Engineers Comments Regarding Surface Water Drainage

Application Reference:	AL/58/26/DOC	Reviewer Reference:	ADC/EXT5/AF
Planning Officer:	Hebe Smith	Date of Review:	27/07/2026
Site Name:	Stanwick Northfields Lane Westergate PO20 3UH		
Application Description:	Approval of details reserved by condition under AL/70/24/HH relating to condition 3- Surface Water Drainage.		
Assessment Number:	1

Application Reference: AL/58/26/DOC Site Name: Stanwick Northfields Lane Westergate PO20 3UH	Initial Issue Date: 21/10/2024 Issue Date: 27/07/2026 Reviewer Reference: ADC/EXT5/AF
---	---

Surface Water Drainage Strategy 2 of 3
24502-ENV-ZZ-00-DR-D-2000

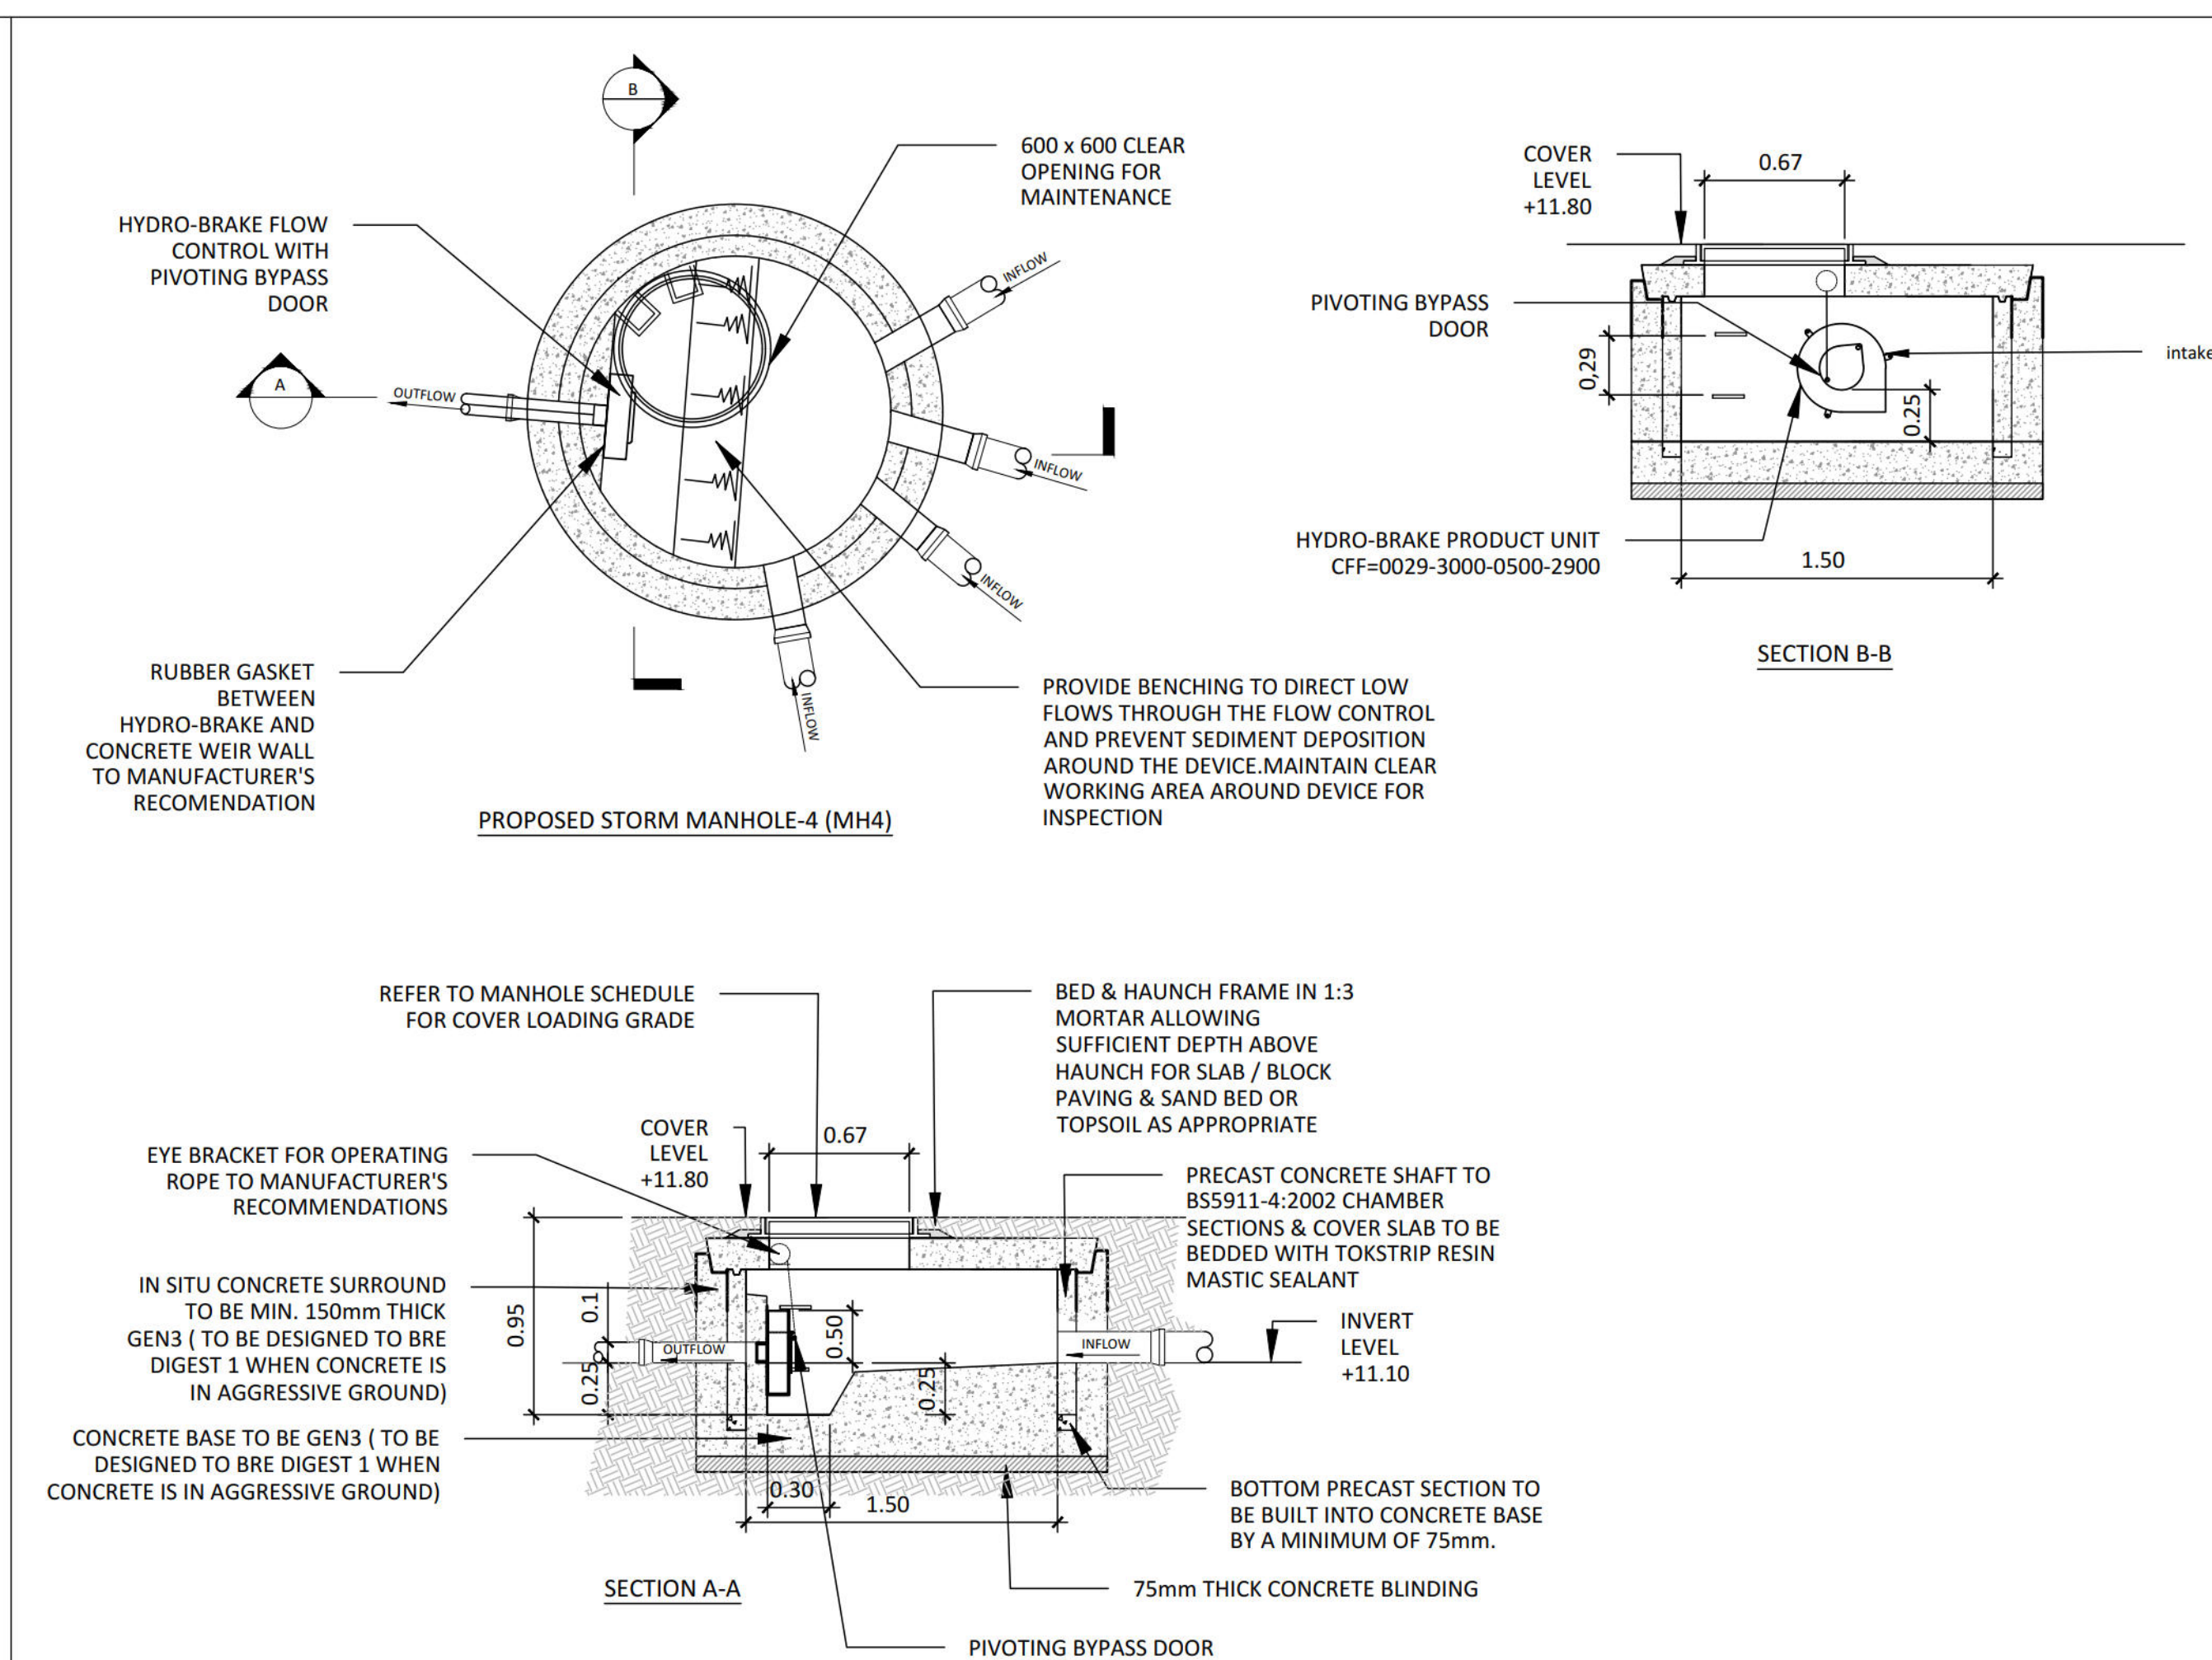
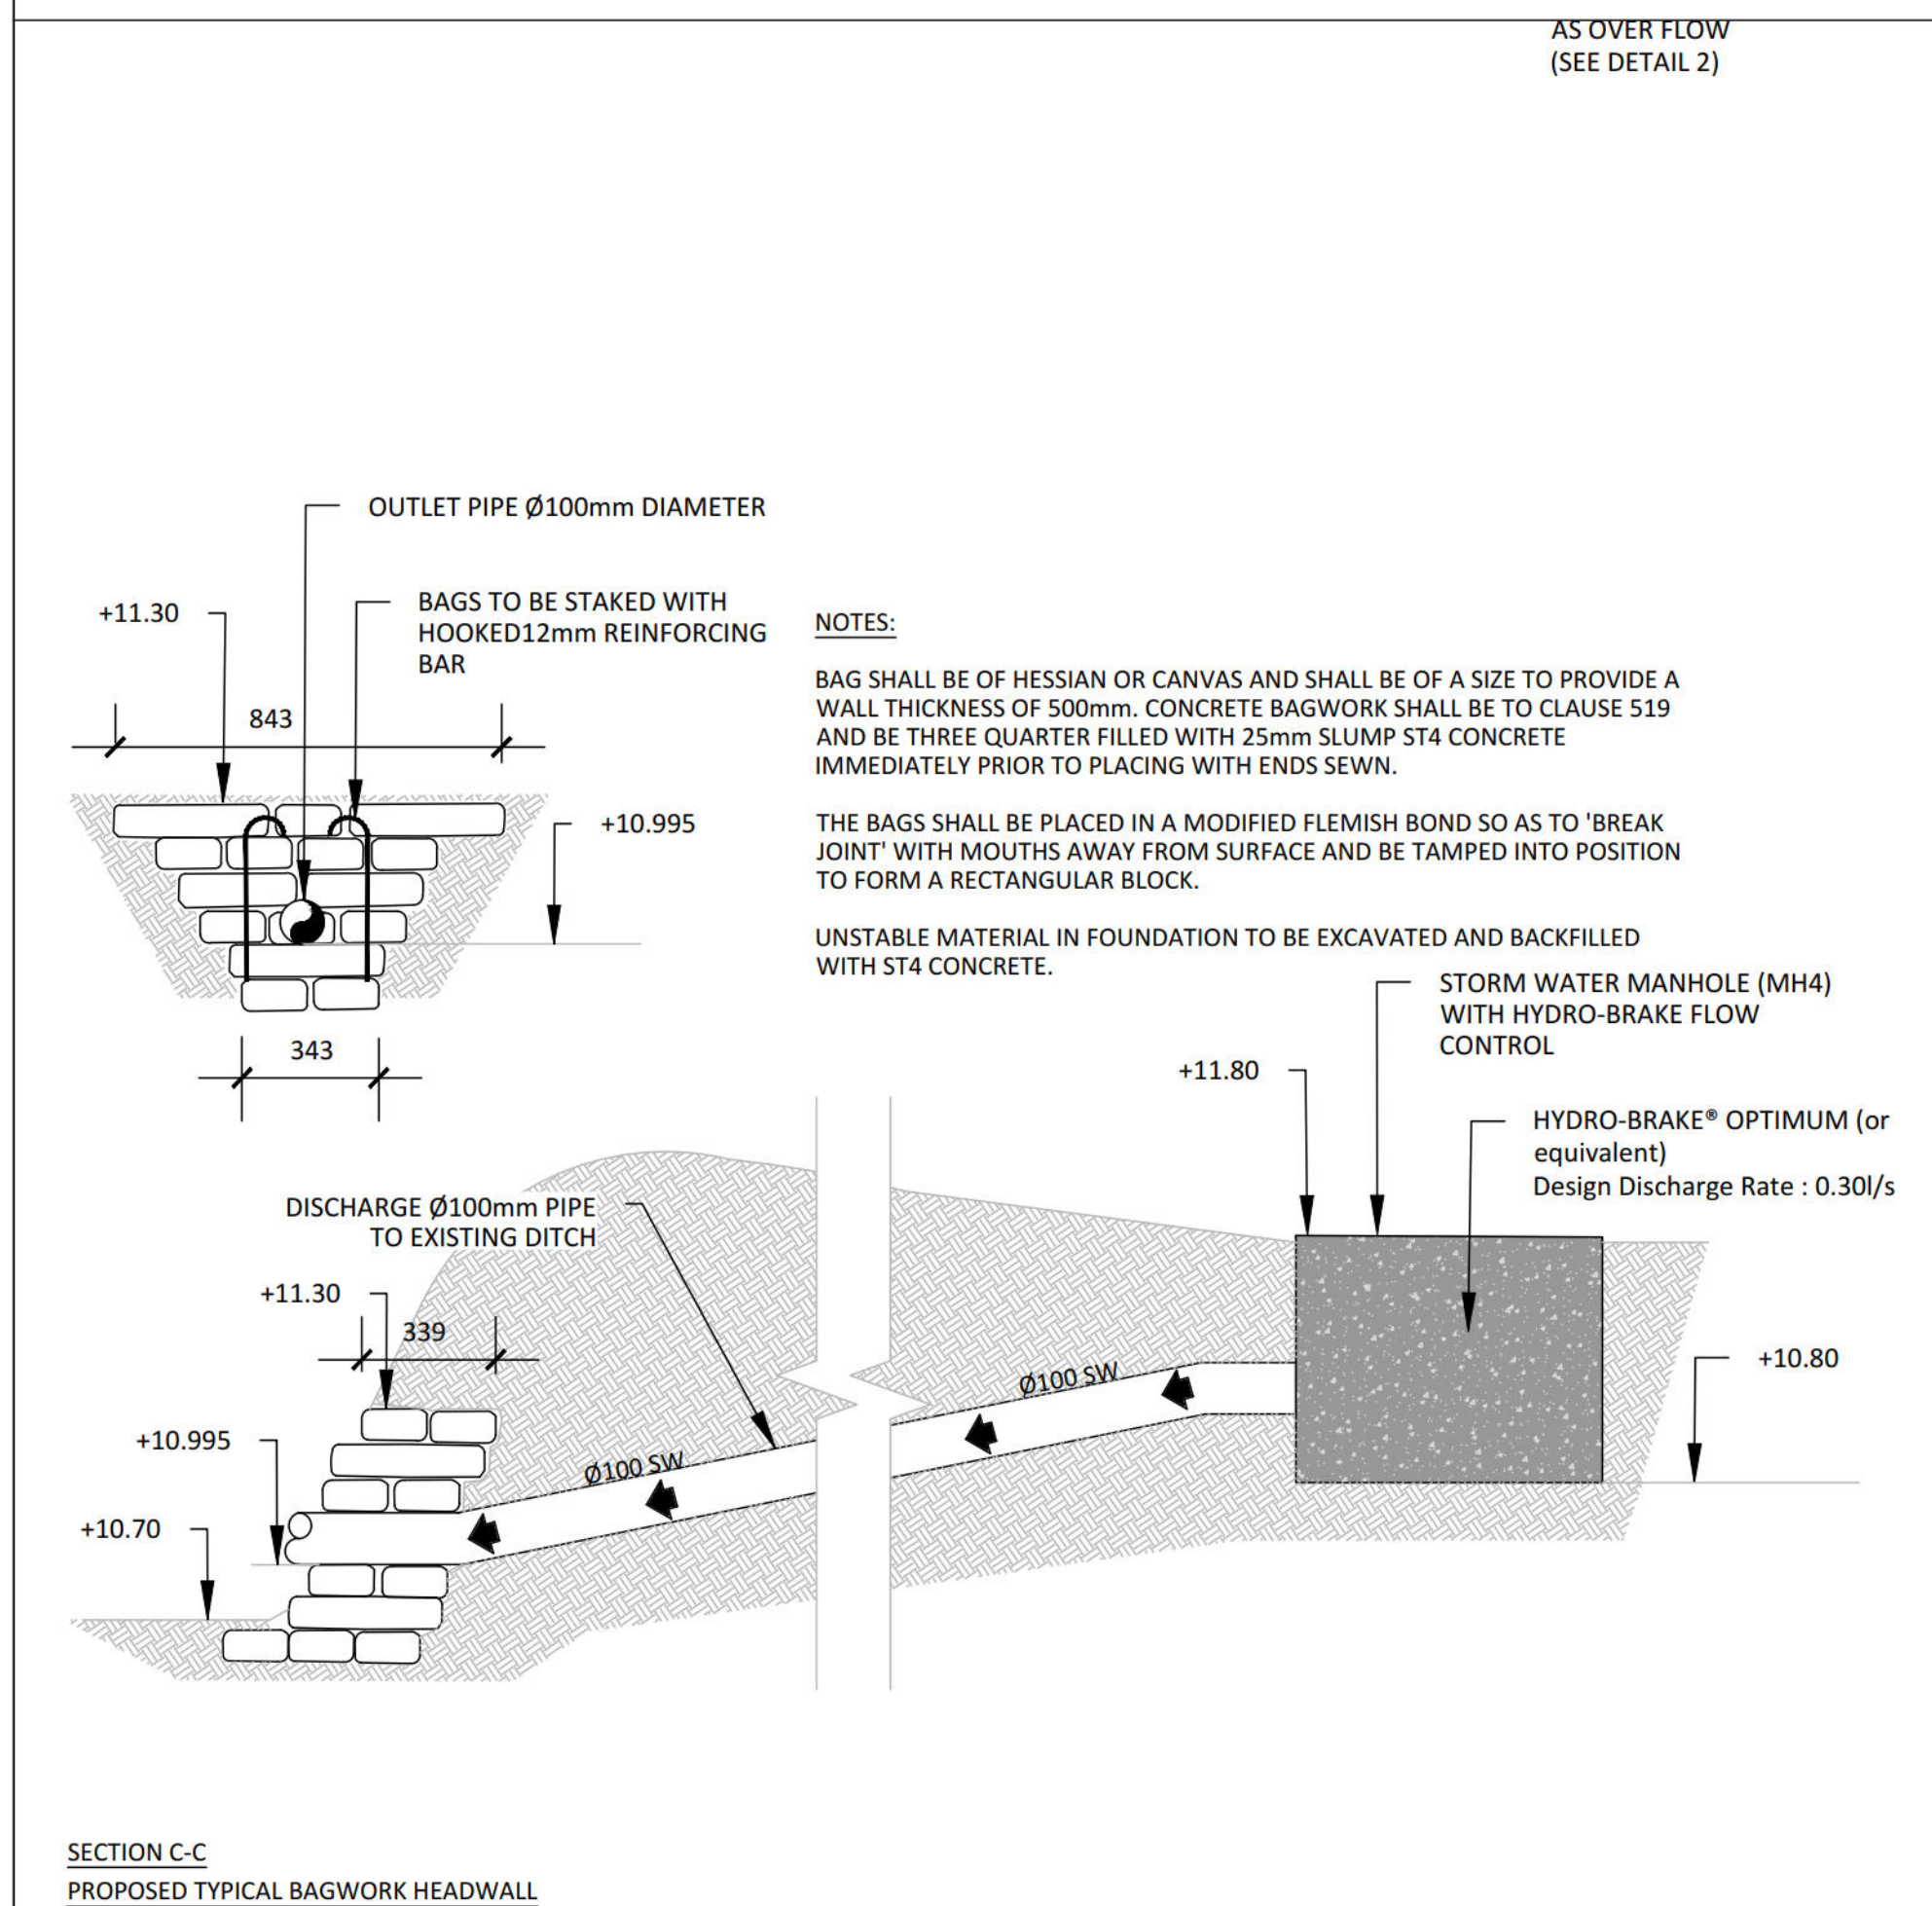
11.	Please submit construction detail drawings for all components – see checklist. ADC Drainage Comments 16/02/2026	Please submit construction detail drawings for all components – see checklist. Particular attention should be paid to the flow control chamber and incorporating	See DS FRADS Giles Vos Rev 03 Appendix E Surface Water Drainage Strategy 1 of 3 24502-ENV-ZZ-00-DR-D-1000	Comment closed.

Please submit construction detail drawings for all components – see checklist. Particular attention should be paid to the flow control chamber and incorporating blockage protection within and upstream as the flow control device size is highly susceptible to blockage.	blockage protection within and upstream as the flow control device size is highly susceptible to blockage. Please confirm that all pipes can be easily and safely inspected accessed from the proposed chambers. The type of construction appears to obscure visibility and access of some pipes from surface level, and they do not appear to be suitable for entry.	Silt traps are upstream of the flow control chamber. manholes provide access points for rodding. See DS FRADS Giles Vos Rev 03 Appendix F and G Surface Water Drainage Strategy 2 and 3 of 3 24502-ENV-ZZ-00-DR-D-2000 and 24502-ENV-ZZ-00-DR-D-3000 for construction details
